Summary comments.

The solar park is located within North Kesteven District and the eastern boundary of the site runs along the Borough / District boundary. The Borough has residents that are about 800m from the site boundary. One dwelling that fronts the A17 will be about 450m from the solar park and will have the cable route pass to its north and east. The impact of the solar park on Boston Borough residents is reduced by distance, any intervening natural and built landscape features and the proposed boundary hedge to the solar park.

We have undertaken a high-level review of the submitted documents focussing on topics that directly or indirectly impact the Borough's residents. We make the following Relevant Representation, which can be summarised as follows:

FIGURE 8.4 PHASE 1 HABITAT SURVEY

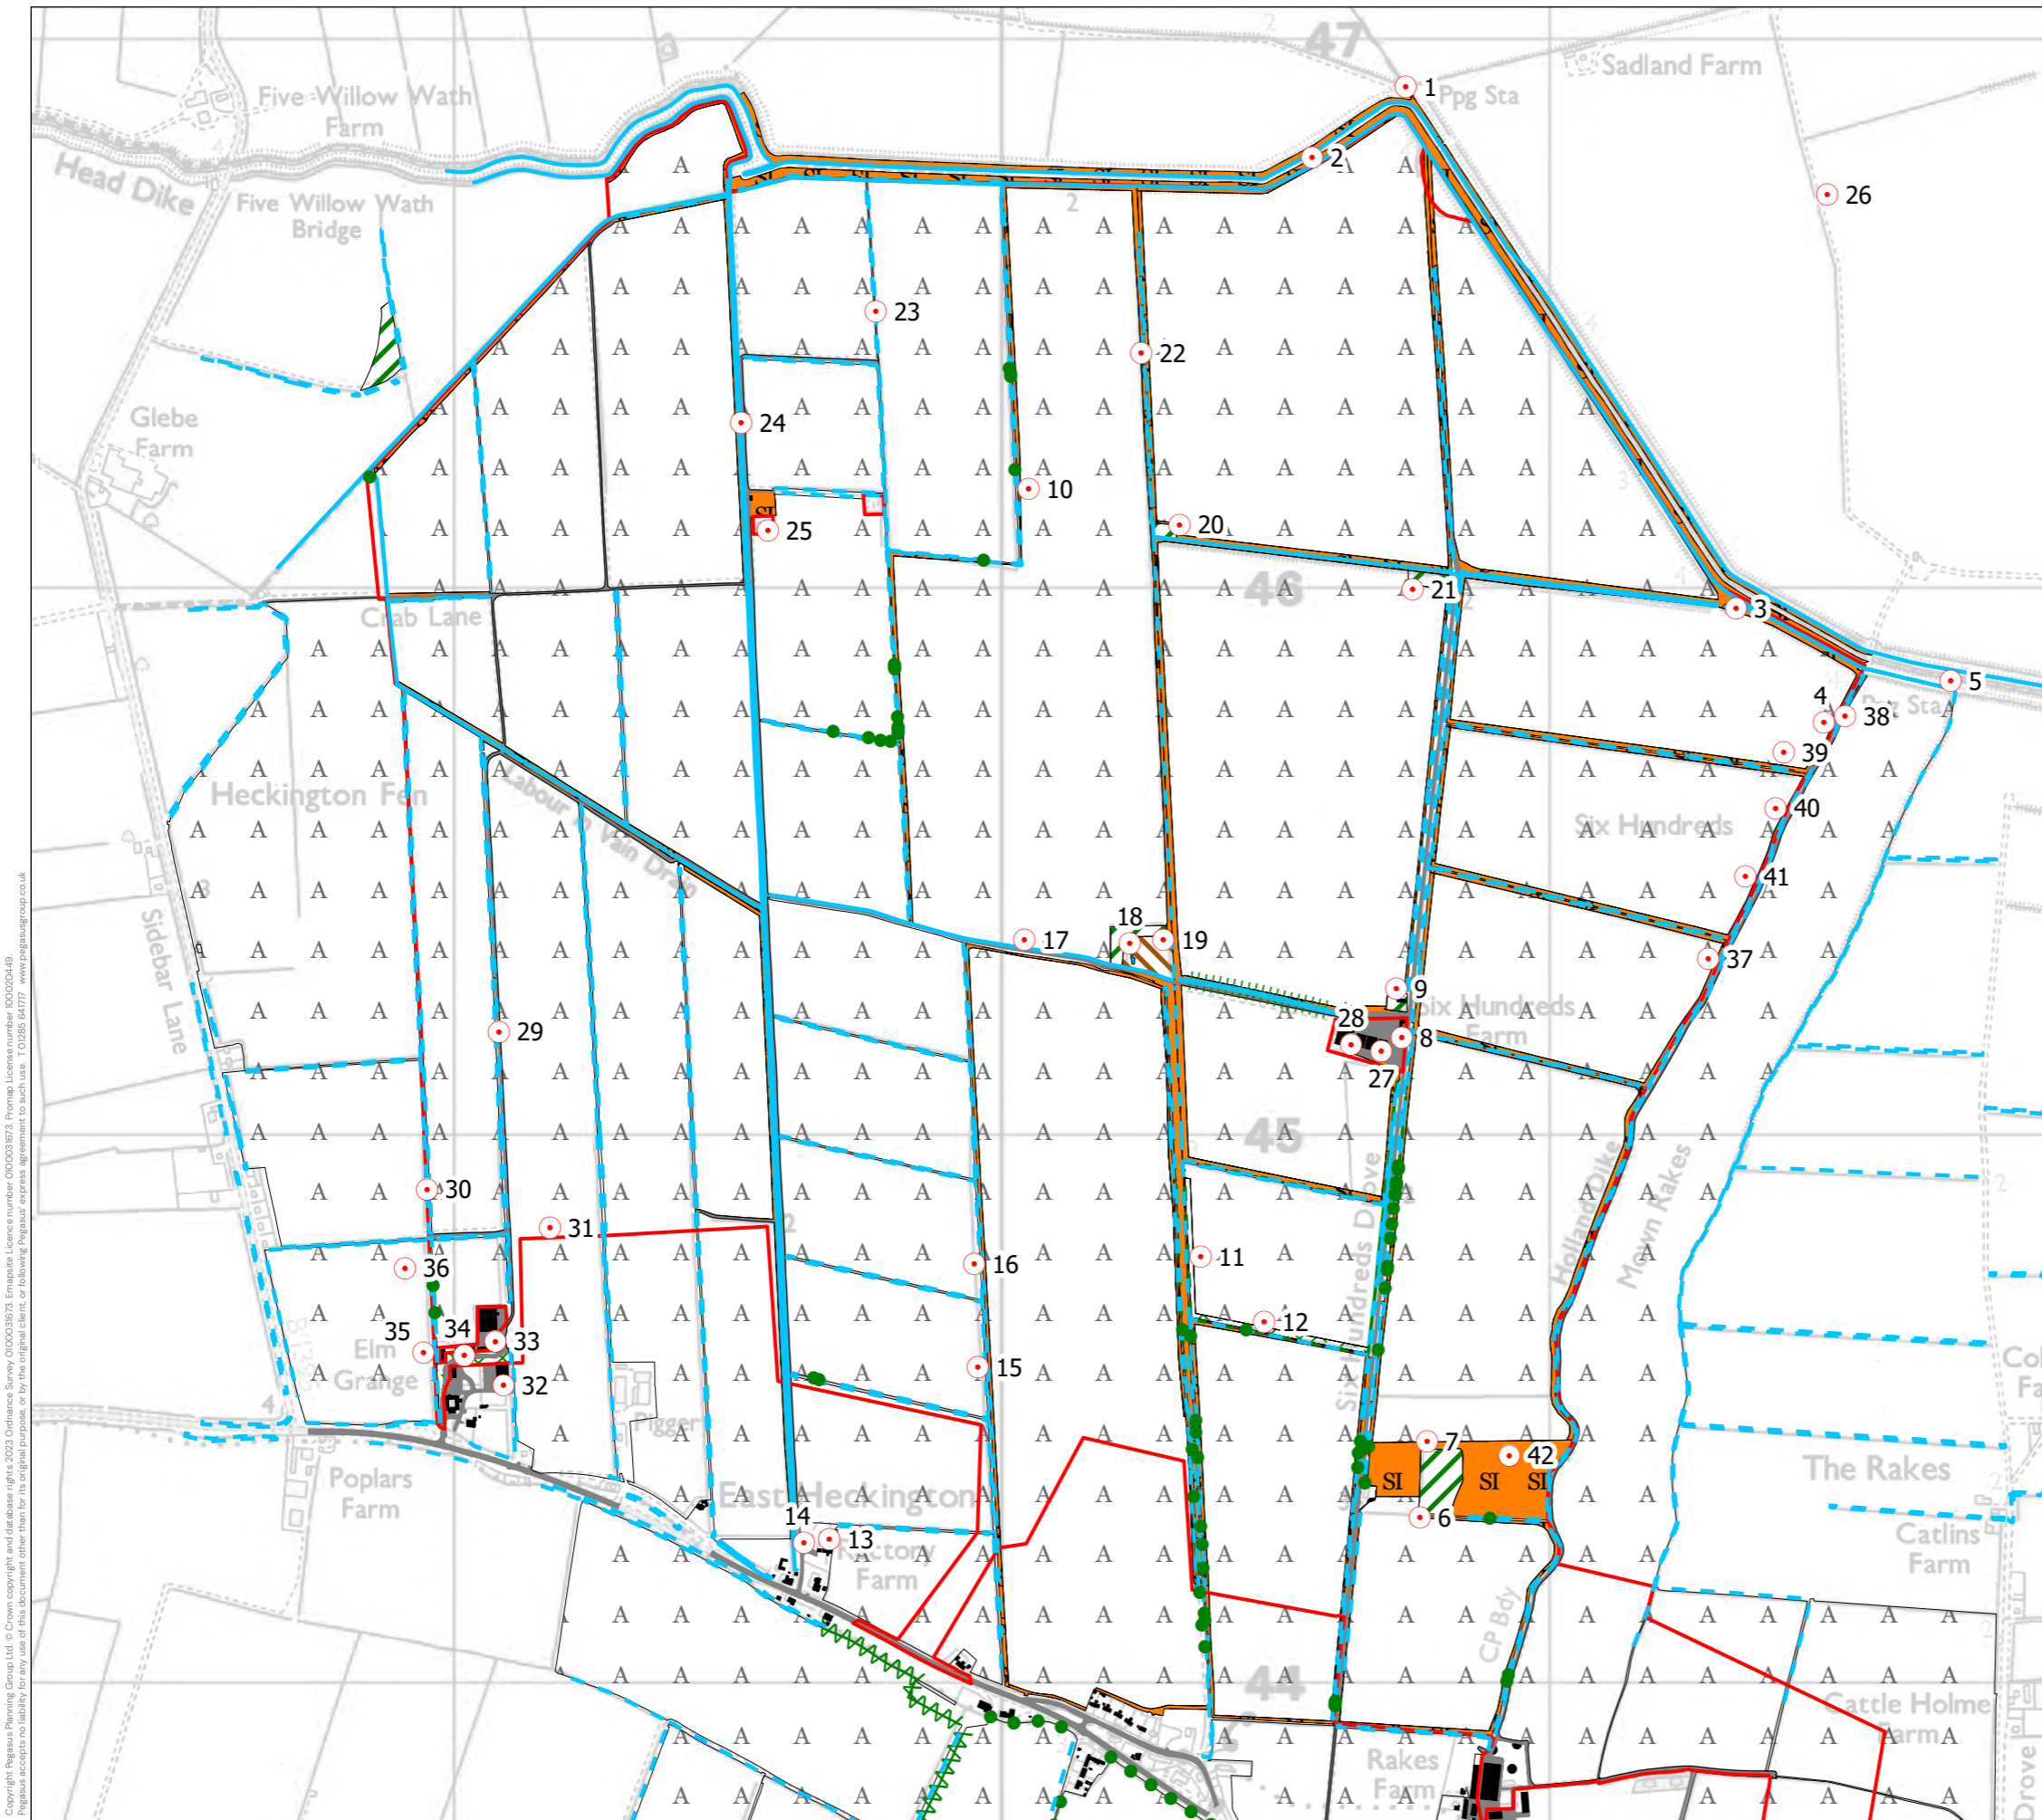
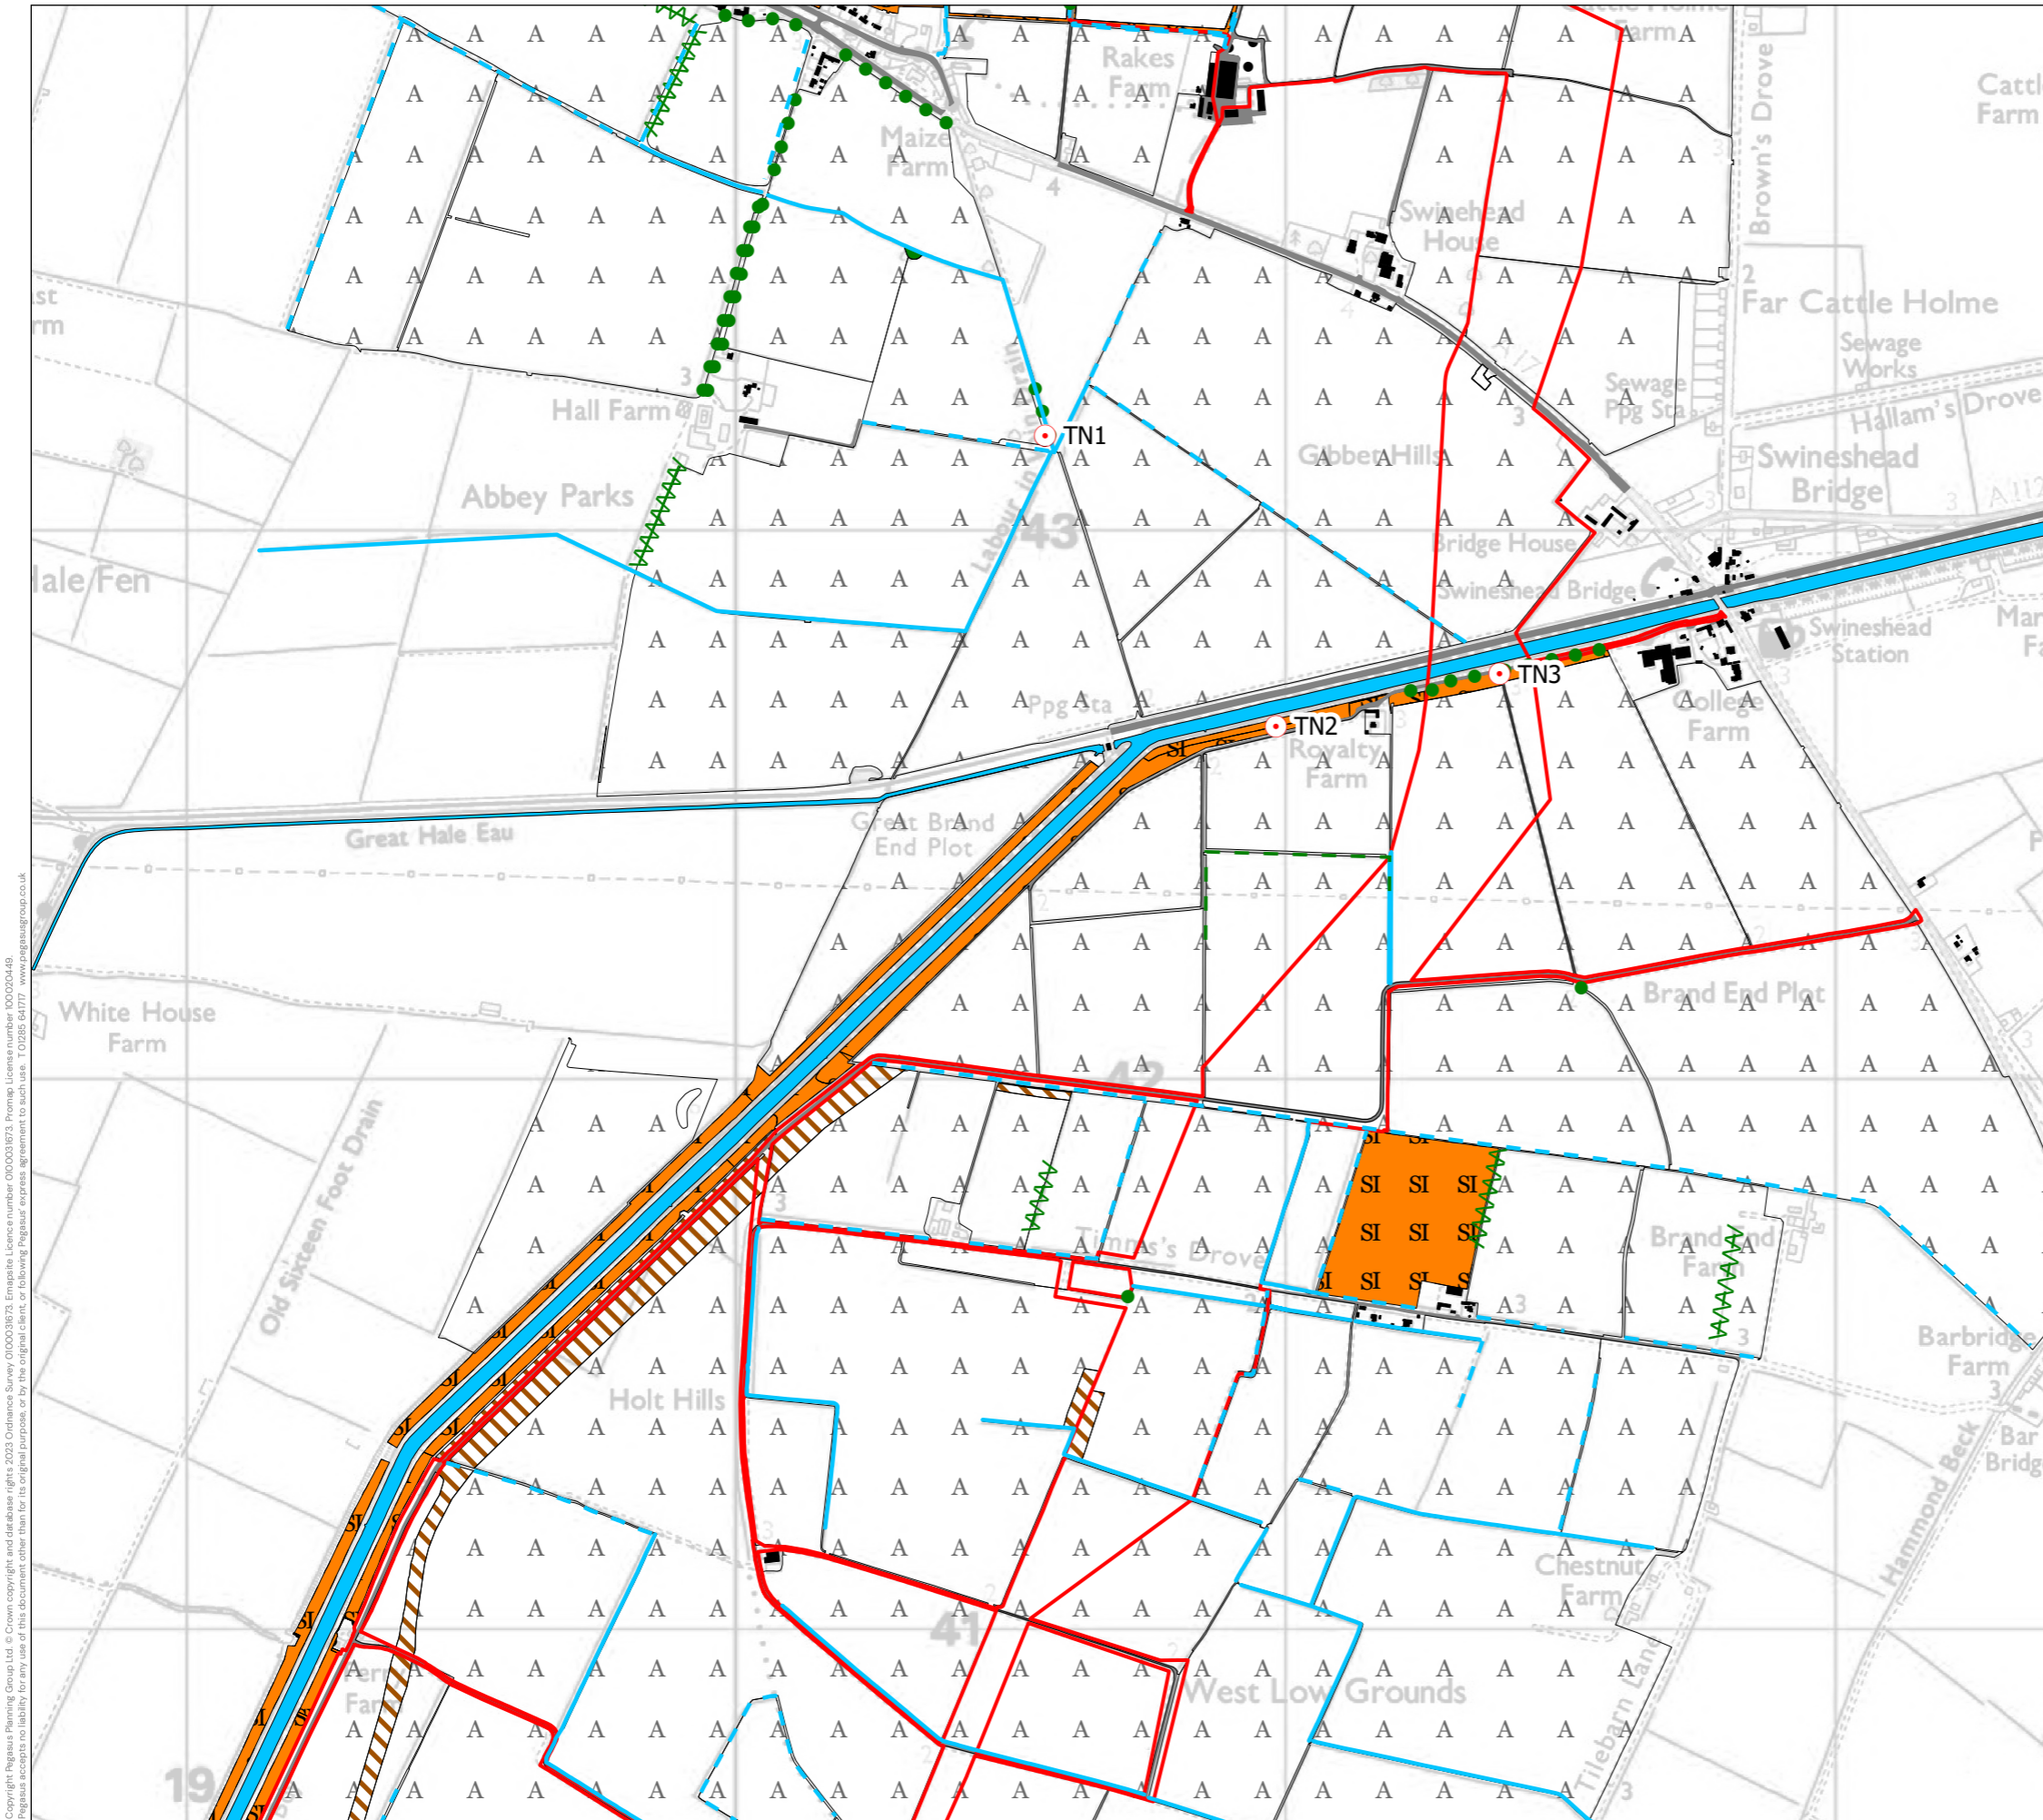
- The documentation explains the evidence work that has been undertaken on the solar park and the cable route. The majority of the land is considered to be of low conservation value. Biodiversity net gain is to be achieved on the Energy Park. What can be achieved along the cable route to link the new habitat on the solar park with landscaping around the Bicker Fen National Grid, Triton Knoll and Viking Link substations plus mitigation of impacts on the South Forty Foot Drain Local Wildlife Site?;
